EL PASO COUNTY GRADING AND EROSION CONTROL PLAN CHECKLIST

PPR2324

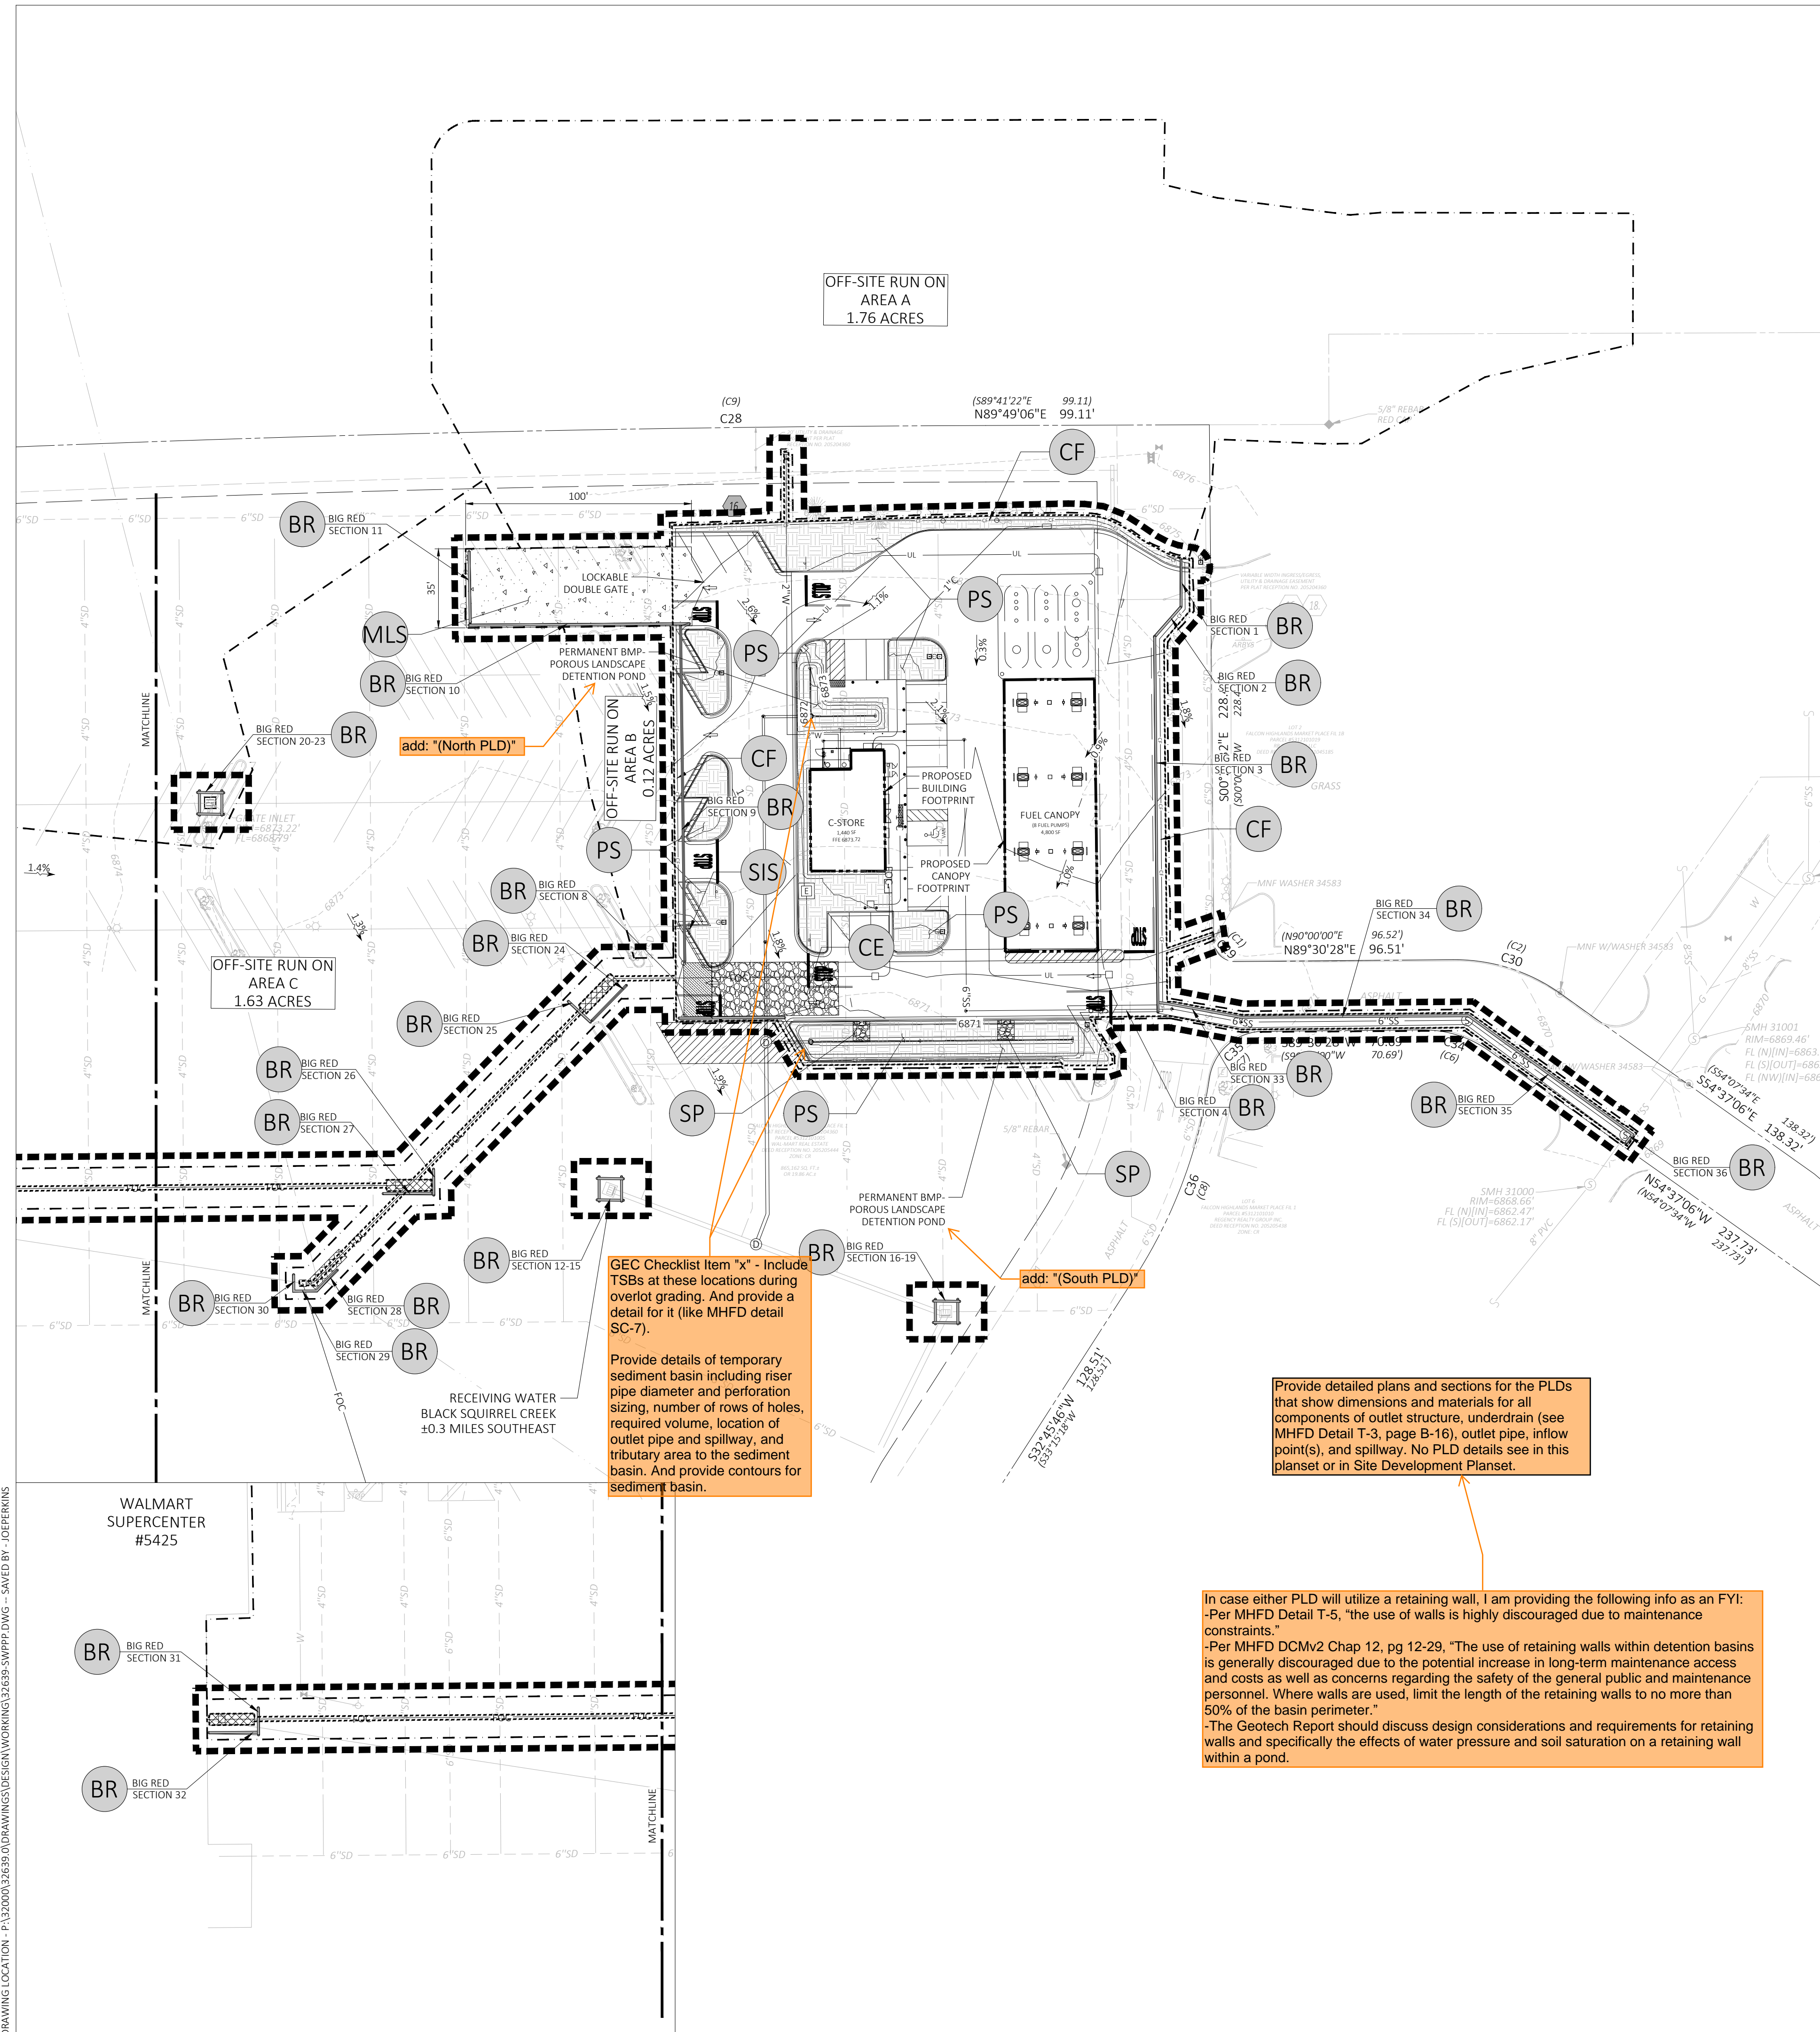
Qty=1 shown on FAE, but none shown on GEC Plans. Show on plans and see my comment on Sht 7
